PUBLIC WORKS DEPARTMENT
SIDEWALK & DRIVEPAD INSPECTION

PROJECT TITLE: Burger King - Wyoming ZONE ATLAS/DRNG. FILE #: F-19/D36
DRB#: 98-213 EPC #: WORK ORDER #:
LEGAL DESCRIPTION: Tract "B", Block 1, American Heritage North Unit 3
CITY ADDRESS: 5315 Wyoming Blvd. NE
ENGINEERING FIRM: Chavez-Grieves CONTACT: Joseph DeFronzo
ADDRESS: 5639 Jefferson NE PHONE: 344-4080
OWNER: M&M Bros. Inc. CONTACT: Tom McCollum
ADDRESS: 11000 Bermuda Dunes NE Alb. 87111 PHONE: 292-5744
ARCHITECT: Nims-Calvani CONTACT: Myron Saldyt
ADDRESS: 525 San Pedro NE Ste. 110 PHONE: 255-6400
SURVEYOR: Harris Surveying CONTACT: Anthony Harris
ADDRESS: 2412 Monroe St. NE PHONE: 889-8056
CONTRACTOR: Gerald Martin CONTACT: Bob Cardenes
ADDRESS: 8501 Jefferson NE PHONE: 828-1144

RE: REVISED DRAINAGE PLAN FOR BURGER KING @ WYOMING & SPAIN
(F19-D36) REVISION DATED 8/5/98

RE: REVISED DRAINAGE PLAN FOR BURGER KING @ WYOMING & SPAIN
(F19-D36) REVISION DATED 6/1/98

REVISIONS	
JOB NUMBER	9705
DATE	JUNE 1998
SHEET NUMBER	C1

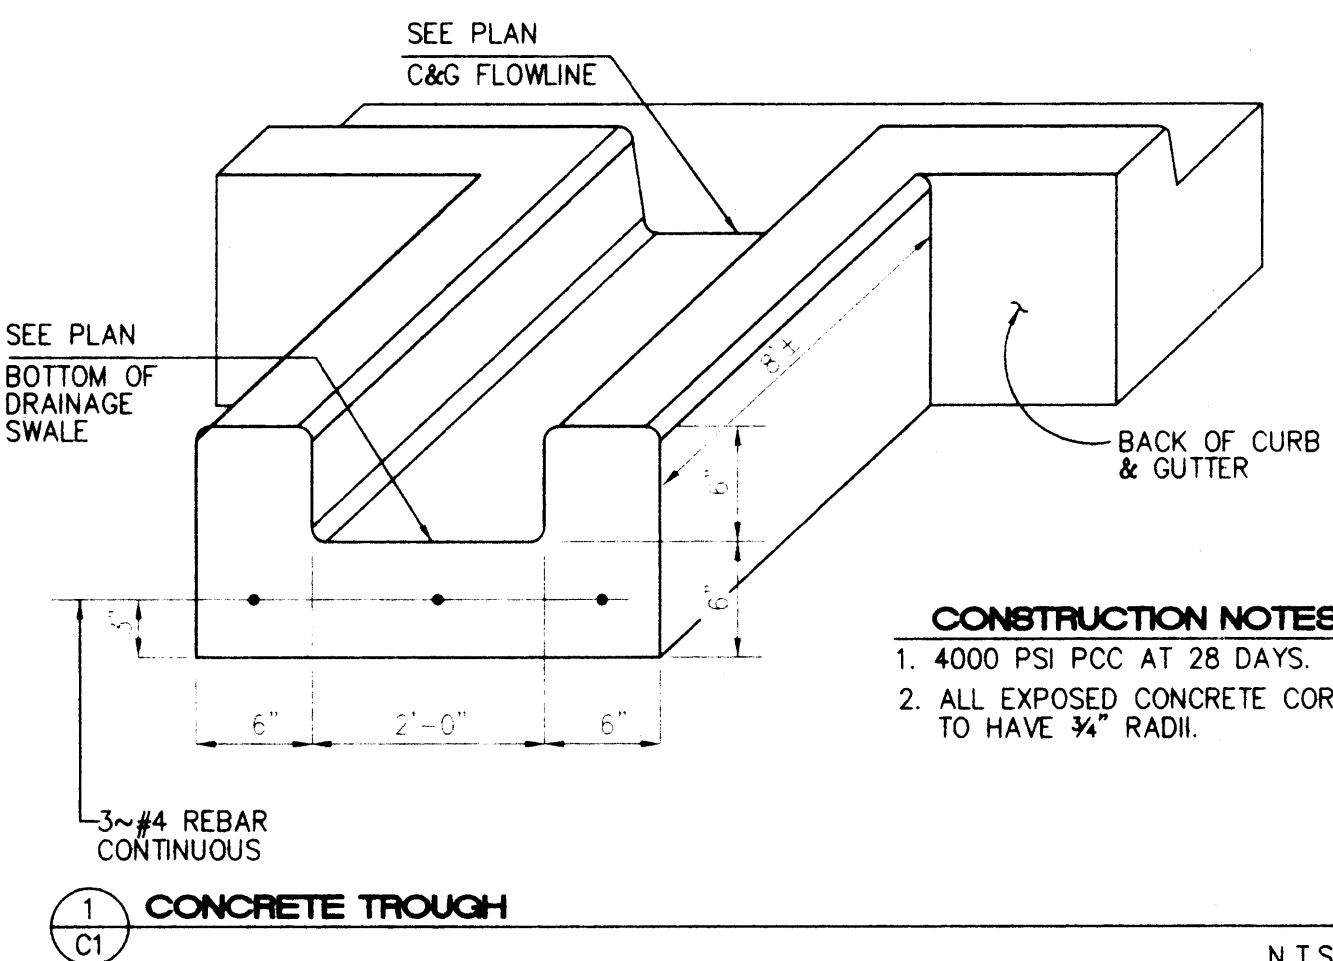
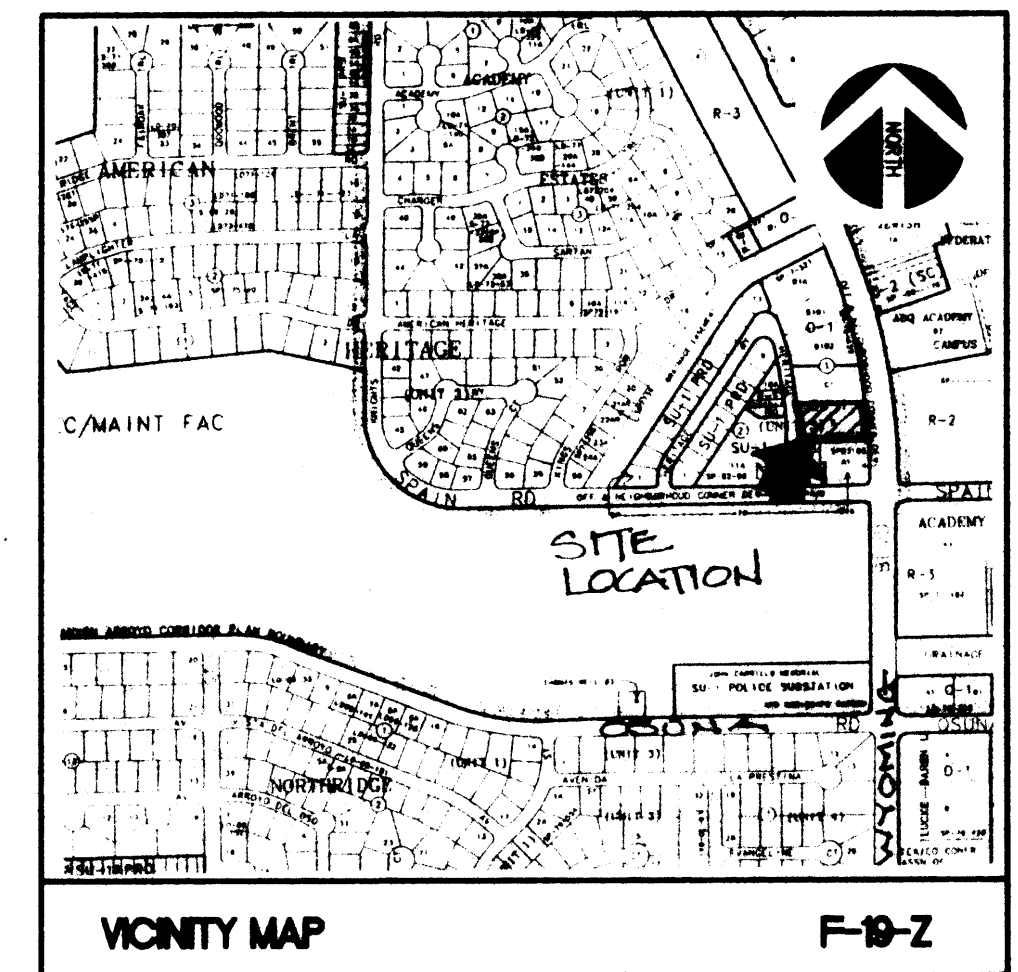
1. Six notes from the DPM checklist for the SO19 format on the plan drawing.
2. Why are you ponding the run-off?
3. According to your plan drawing, you indicate that all the run-off will be discharged onto Heritage Court NE thru the proposed rundown. I am confused in that you identify ponding yet you have the rundown.
4. Your narrative indicates two eight inch pipes, where are they on the plan drawing?
5. I need the hydraulics for the proposed rundown, will it carry the developed run-off?
6. Please check your drivepads for the required one foot water block.

JOB NUMBER: 9705  
DATE: AUGUST 1998  
SHEET NUMBER: C2

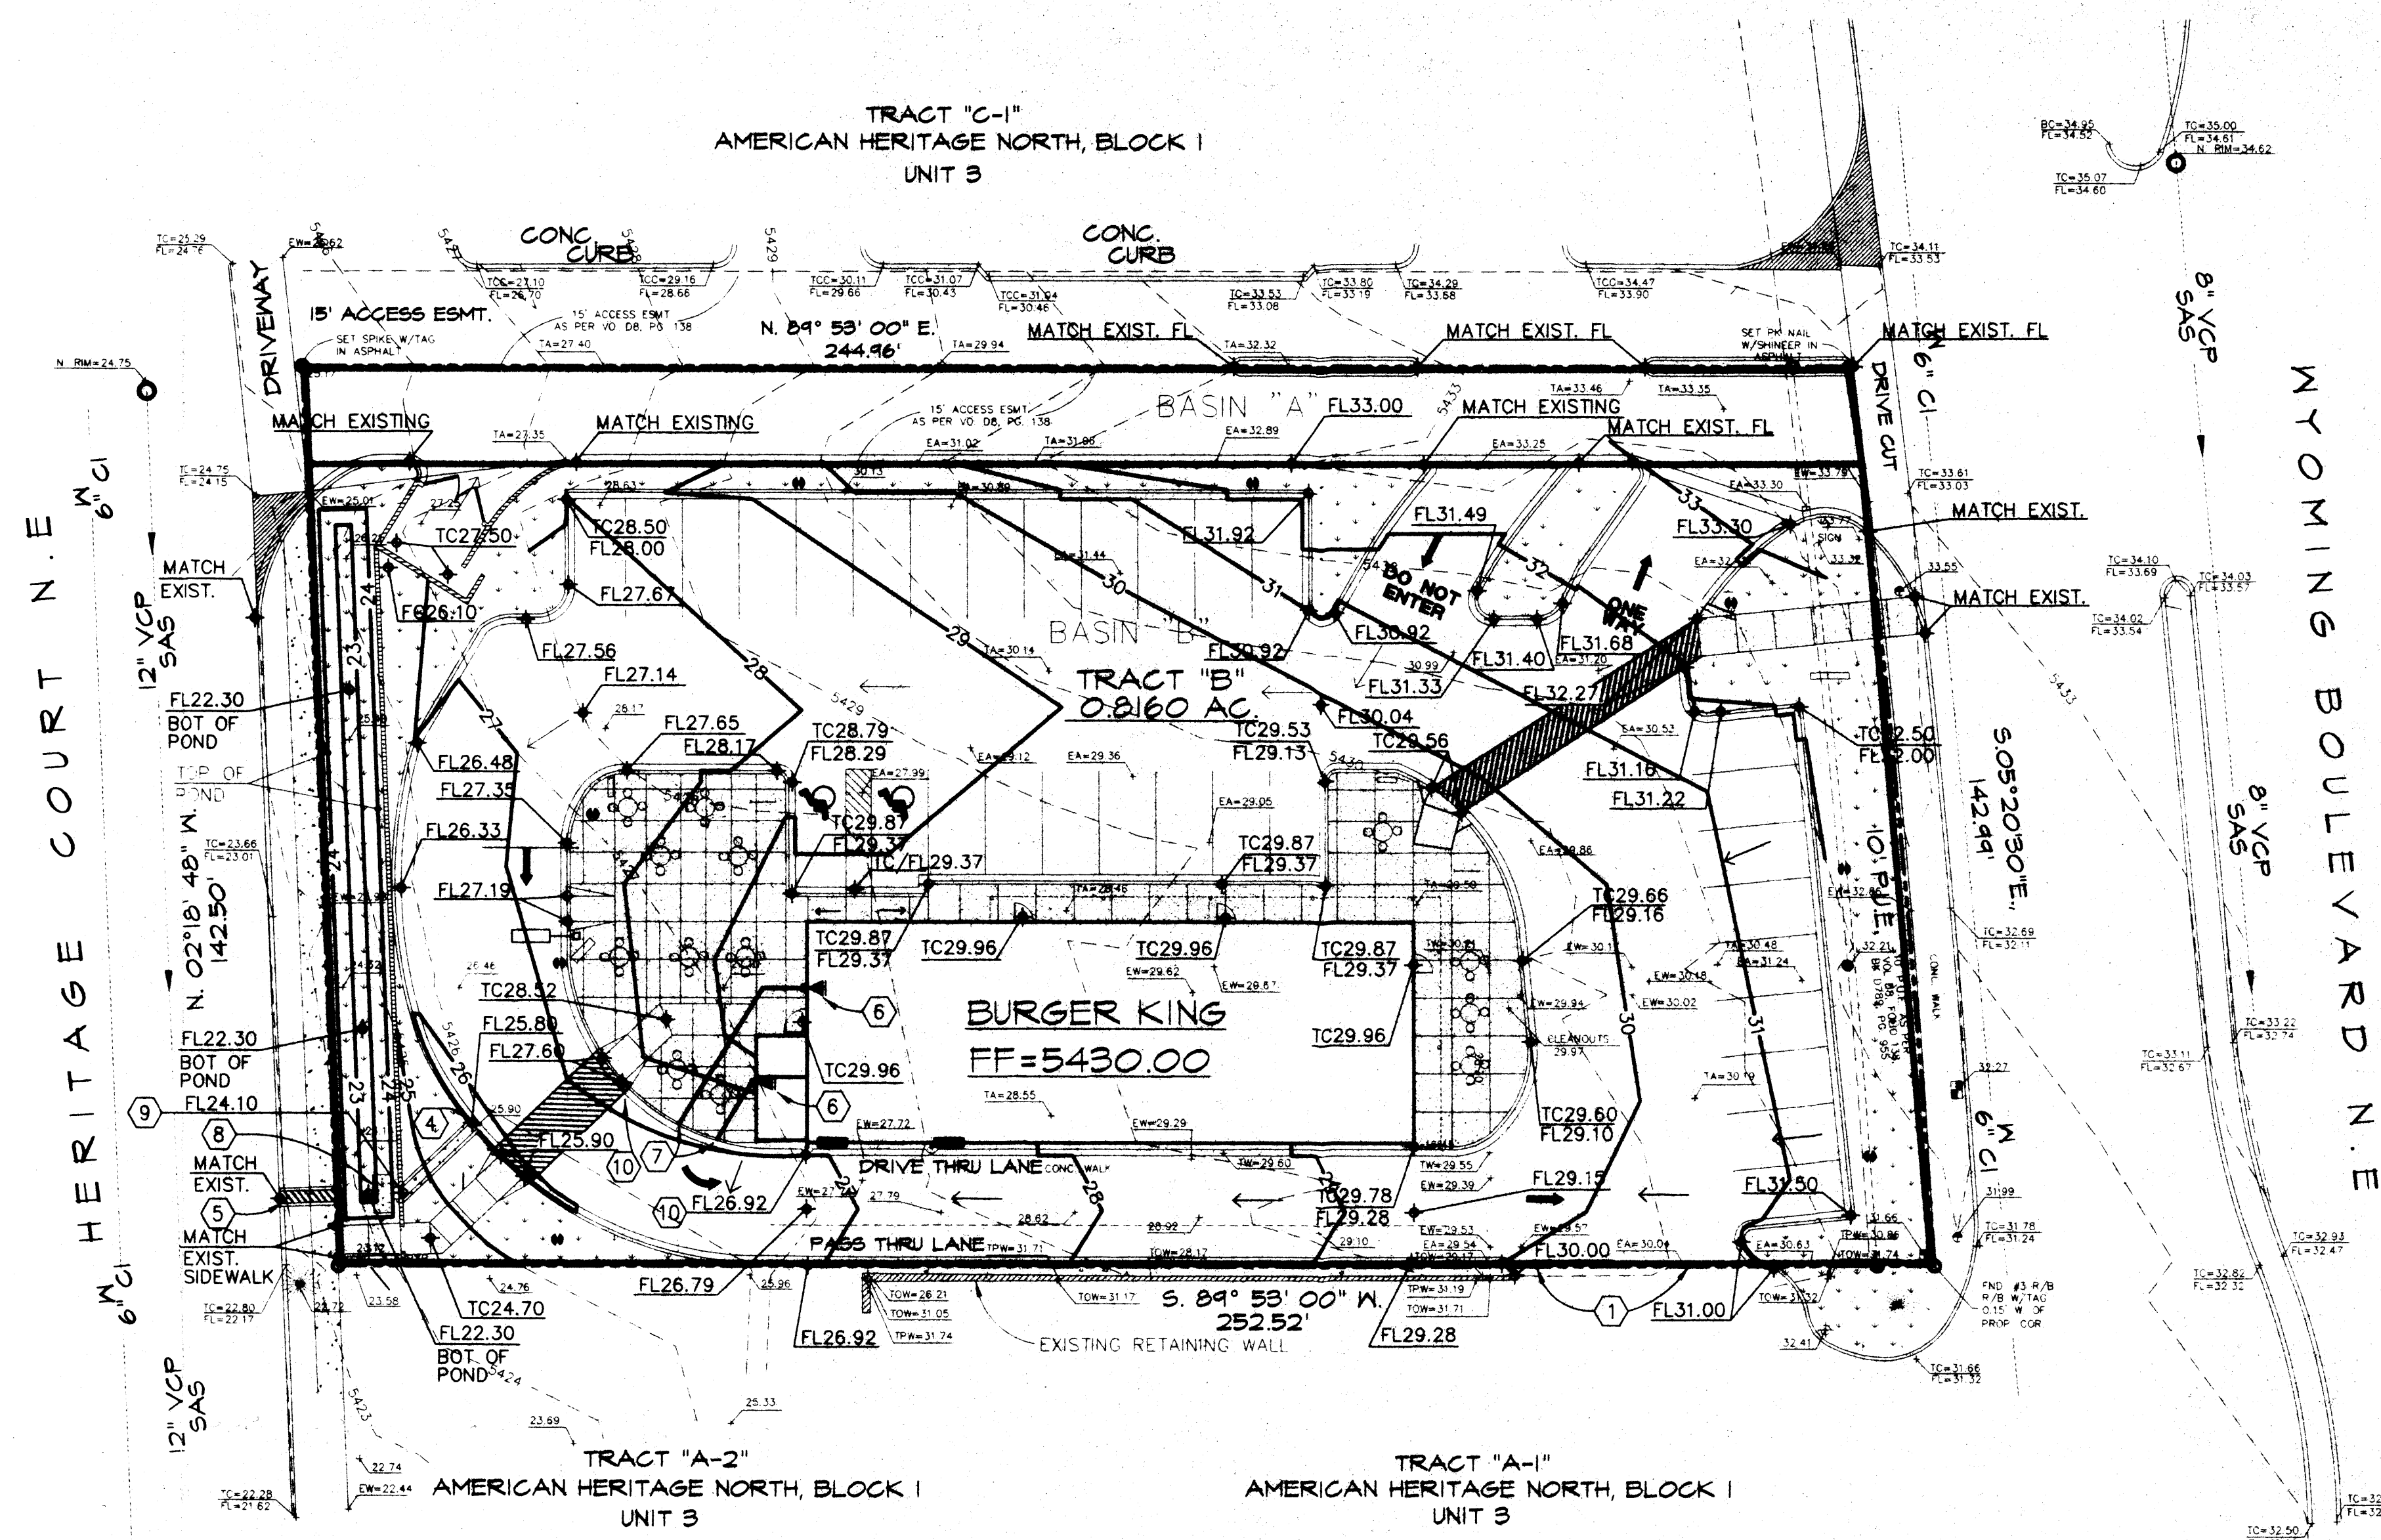
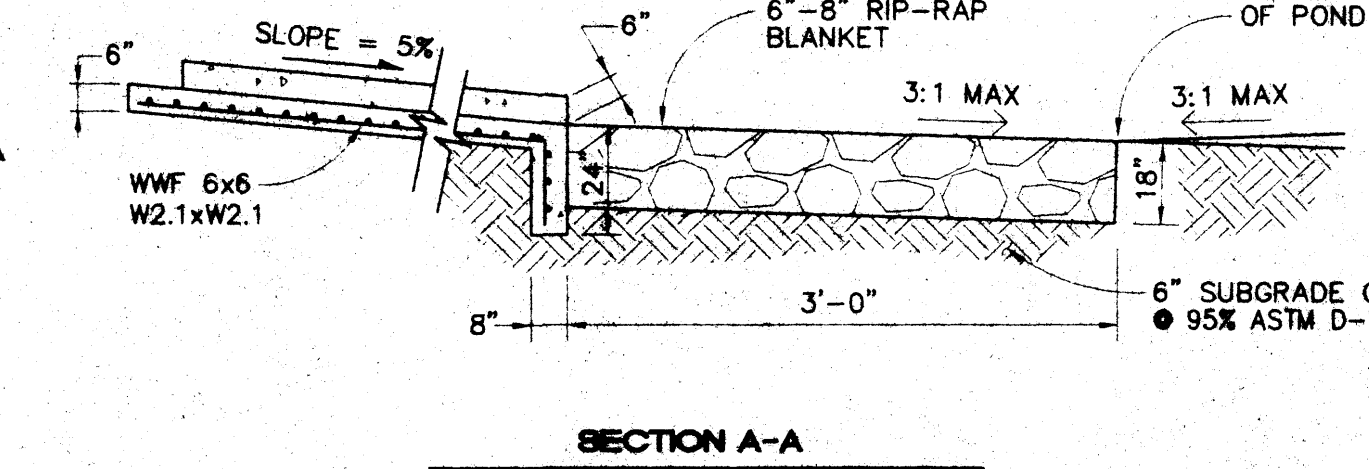
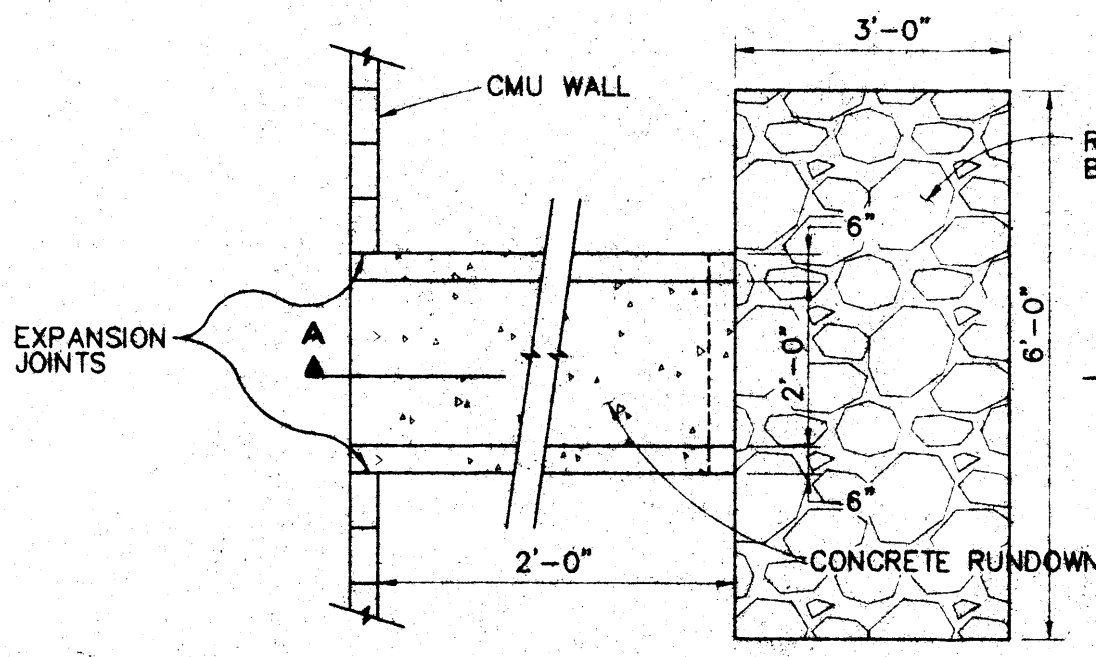
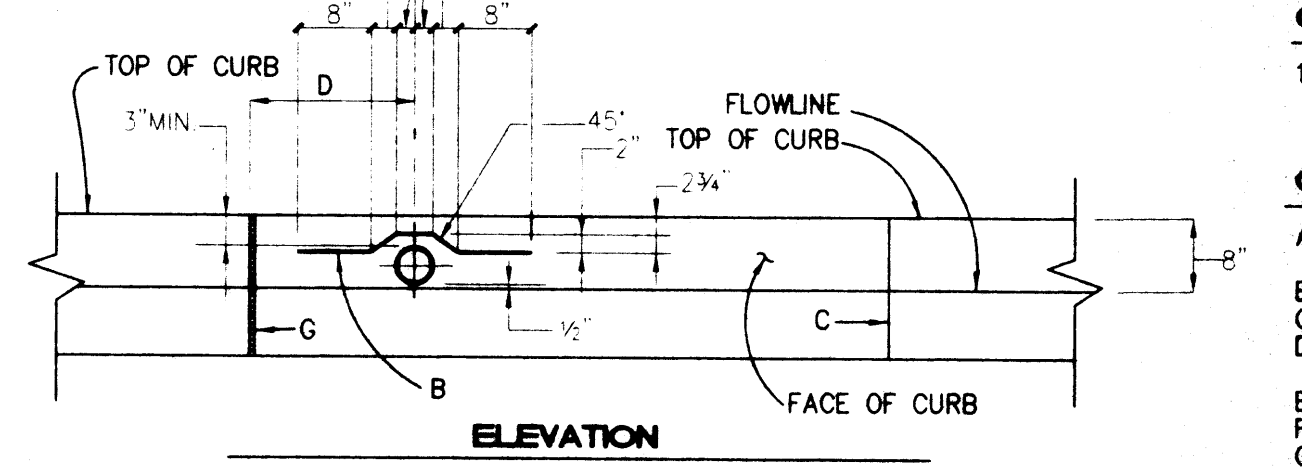
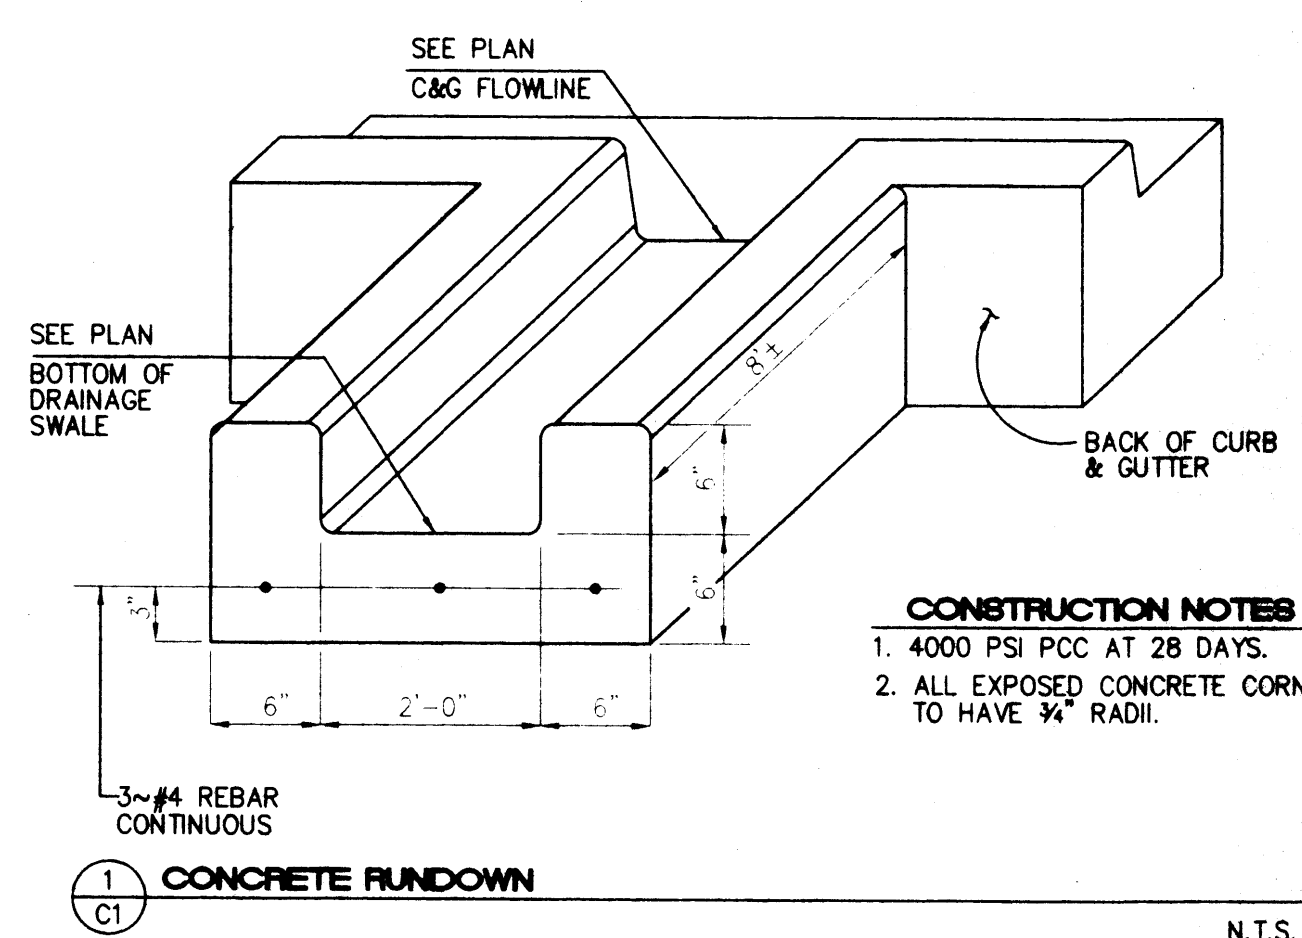
1q. *Six notes from the DPM checklist for the SO19 format on the plan drawing.*

2q. *Why are you ponding the run-off?*

3q. *According to your plan drawing, you indicate that all the run-off will be discharged onto Heritage Court NE thru the proposed rundown. I am confused in that you identify ponding yet you have the rundown.*

4q. *Your narrative indicates two 8" pipes, which are they on the plan drawing?*

5q. *I need the hydraulics for the proposed rundown, will it carry the developed run-off?*

6q. *Please check your drive pads for the required one foot water block.*

1a. **The notes are on the plan sheet.**

2a. **This is what was presented on the Conceptual Grading Plan. The reason is so that the developed flows discharge into Heritage Court will be released at the same flowrate as the undeveloped through a sidewalk culvert.**

3a. **We are channeling the runoff from the site to the concrete rundown then into the detention pond. From the detention pond, the run-off will be discharged to Heritage Court through a sidewalk culvert at the historical flow rate.**

4a. **We have eliminated the pipes all together now.**

5a. We have included the hydraulics for the rundown with this submittal. Yes it is capable of carrying the developed run-off.

6a. We are matching the existing grades at the 15' access easement along the northern property lines. We will have a water block between the gas station to the south and our property.
